# CONSTRUCTION PLANS FOR T.F. STONE BUILDING ADDISON STORAGE ADDITION LOT 1, BLOCK A

*Reviews  
 SZ & P.L.  
 1/20/03*

T.F. STONE COMPANIES, INC.  
T.F. STONE BUILDING  
LOT 1, BLOCK A, ADDISON STORAGE ADDITION  
**DEMOLITION PLAN**  
ADDISON, DALLAS COUNTY, TEXAS

T.F. STONE COMPANIES, INC.  
T.F. STONE BUILDING  
LOT 1, BLOCK A, ADDISON STORAGE ADDITION  
**PAVING AND DIMENSIONAL CONTROL PLAN**  
ADDISON, DALLAS COUNTY, TEXAS

T.F. STONE COMPANIES, INC.
T.F. STONE BUILDING
LOT 1, BLOCK A, ADDISON STORAGE ADDITION
PAVING AND DIMENSIONAL CONTROL PLAN
ADDISON, DALLAS COUNTY, TEXAS

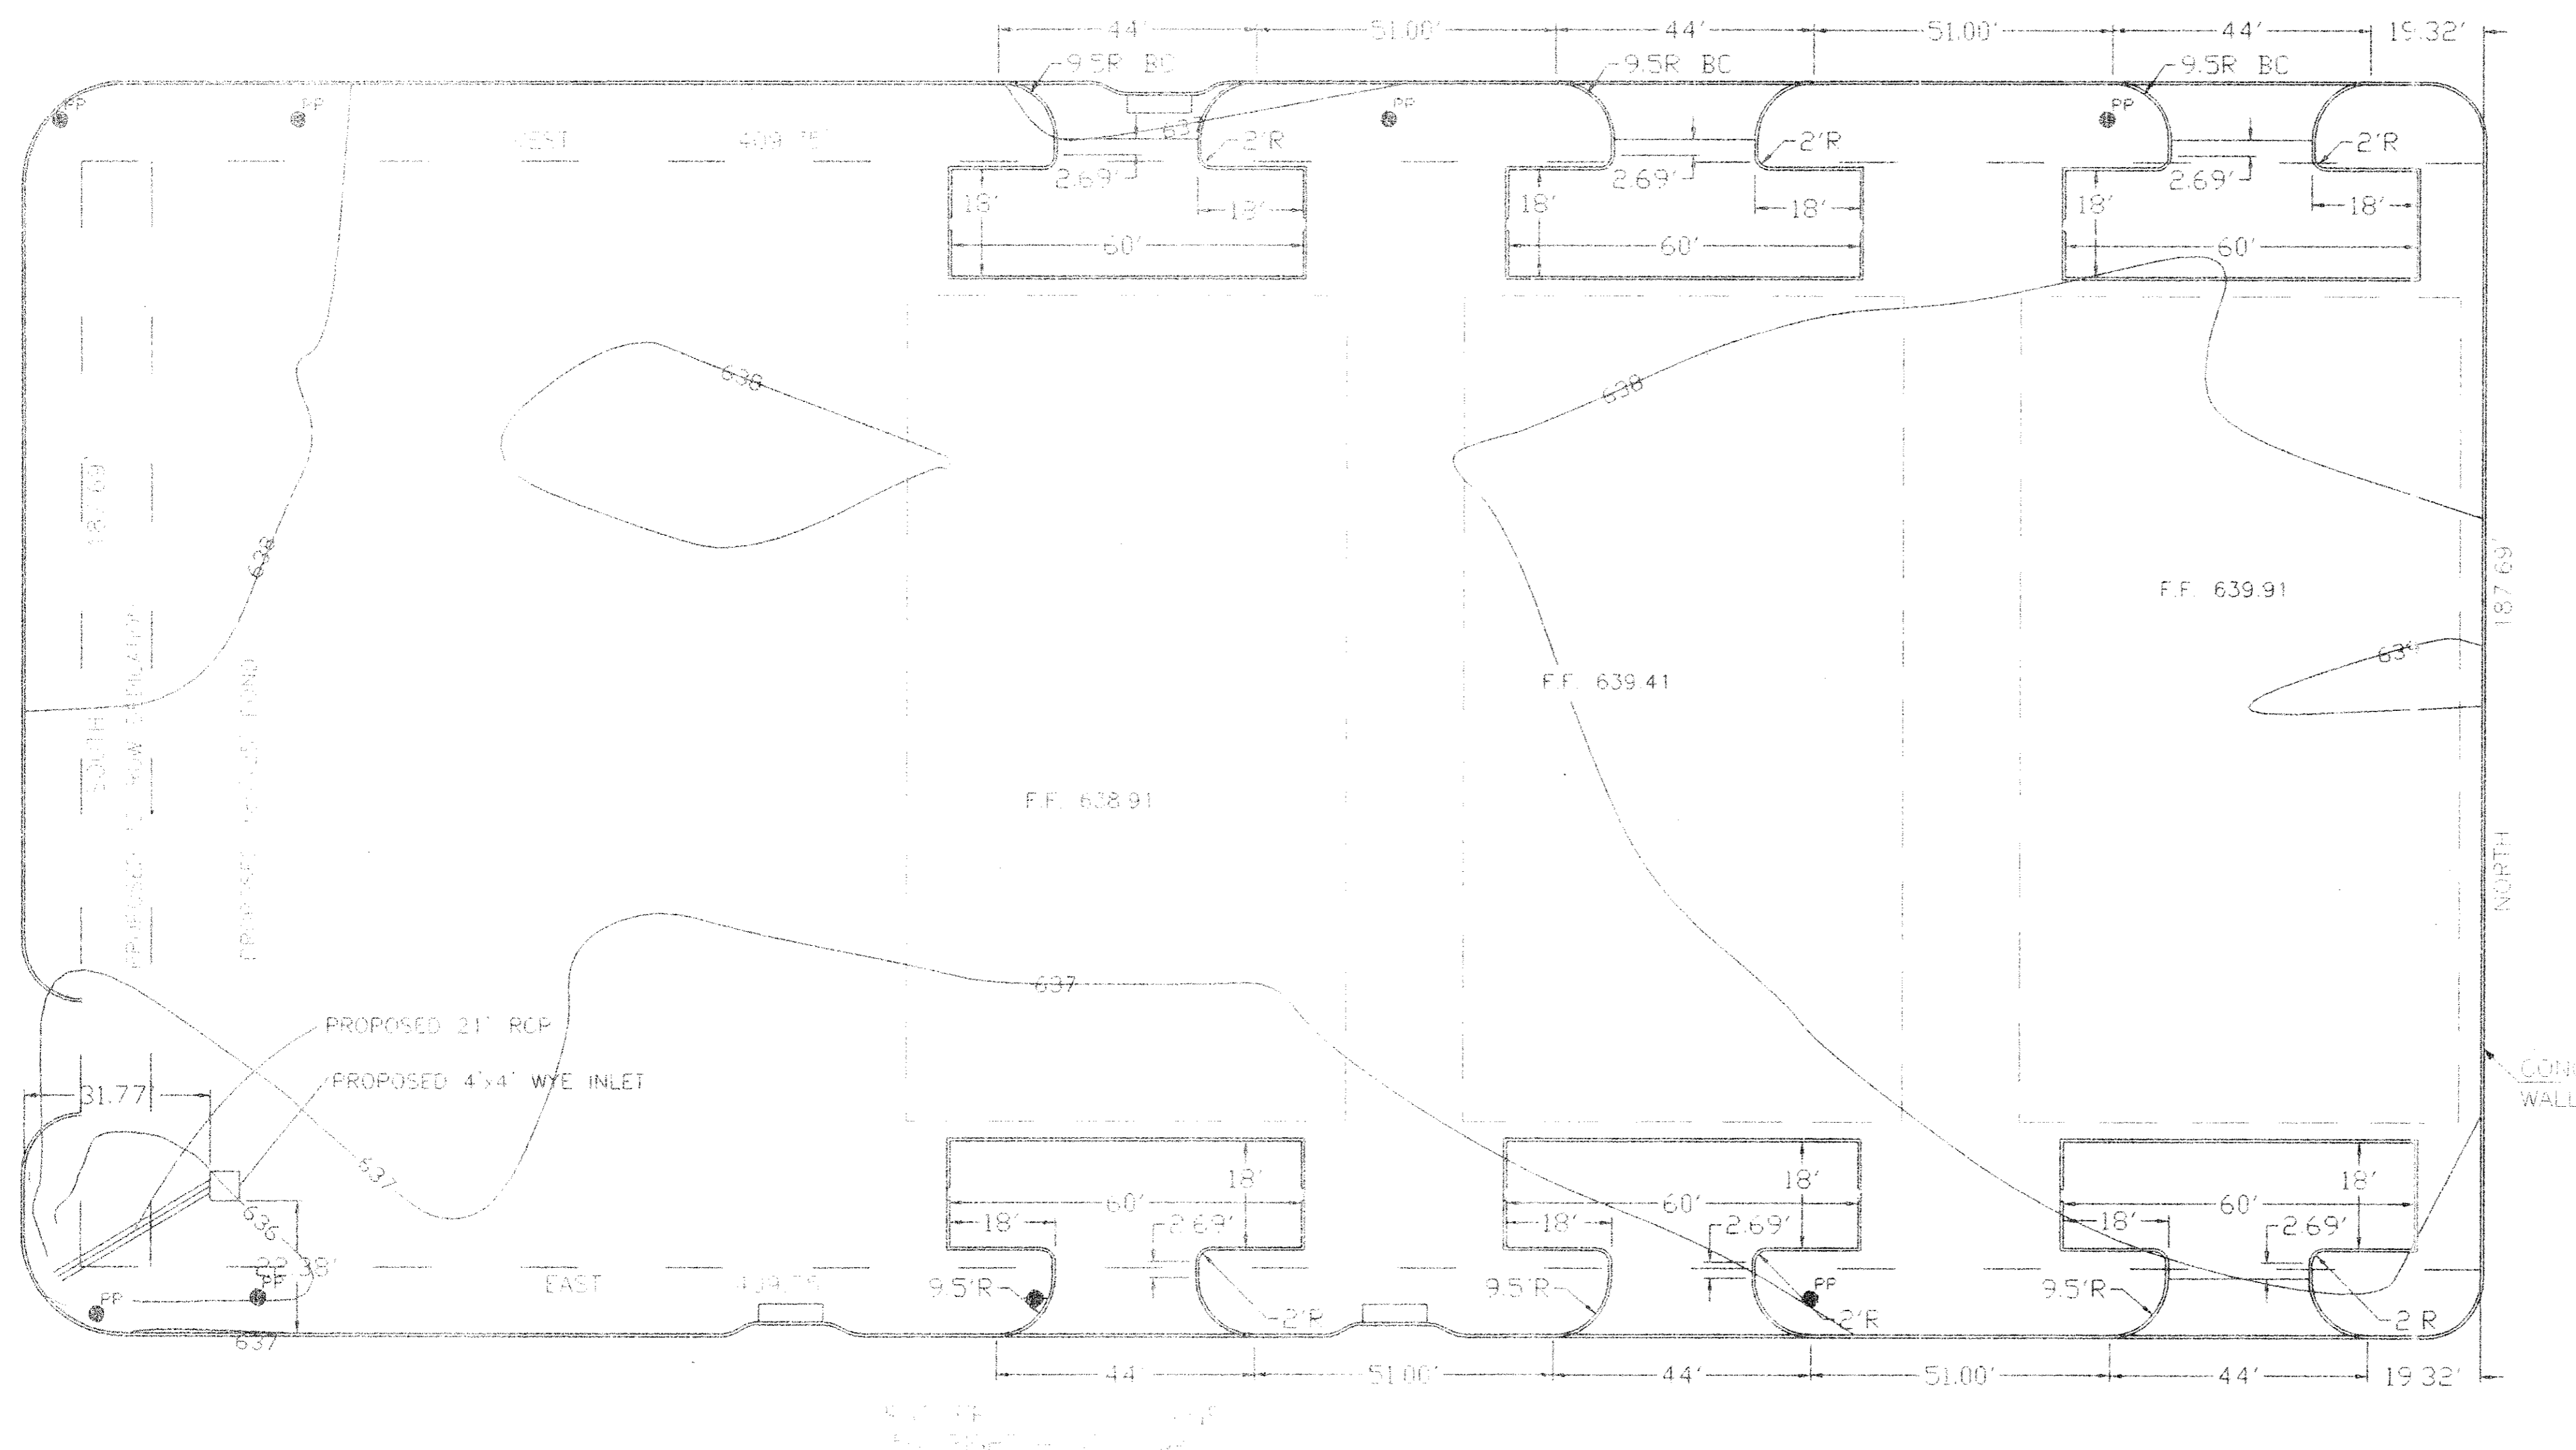
*We need to look at how we want the ramps to look here. There will be some curb removal.*

*Handwritten note: EITHER EXTEND THE SIDEWALK AROUND AS SHOWN, OR PLACE ADA RAMP!*

*Handwritten note: ADA STAIRCASE!*

*Handwritten note: Remove sidewalk*

**CONSTRUCTION DETAILS**

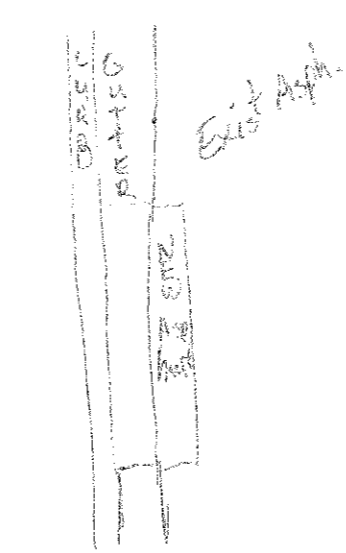
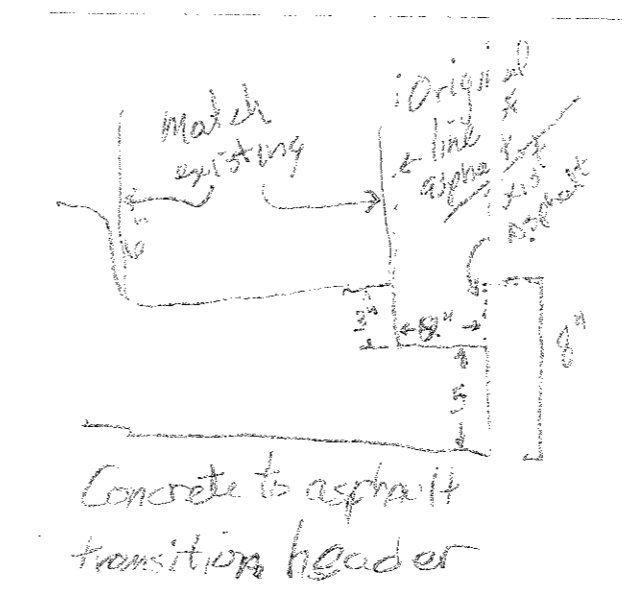
*Show concrete frame detail (s)!*
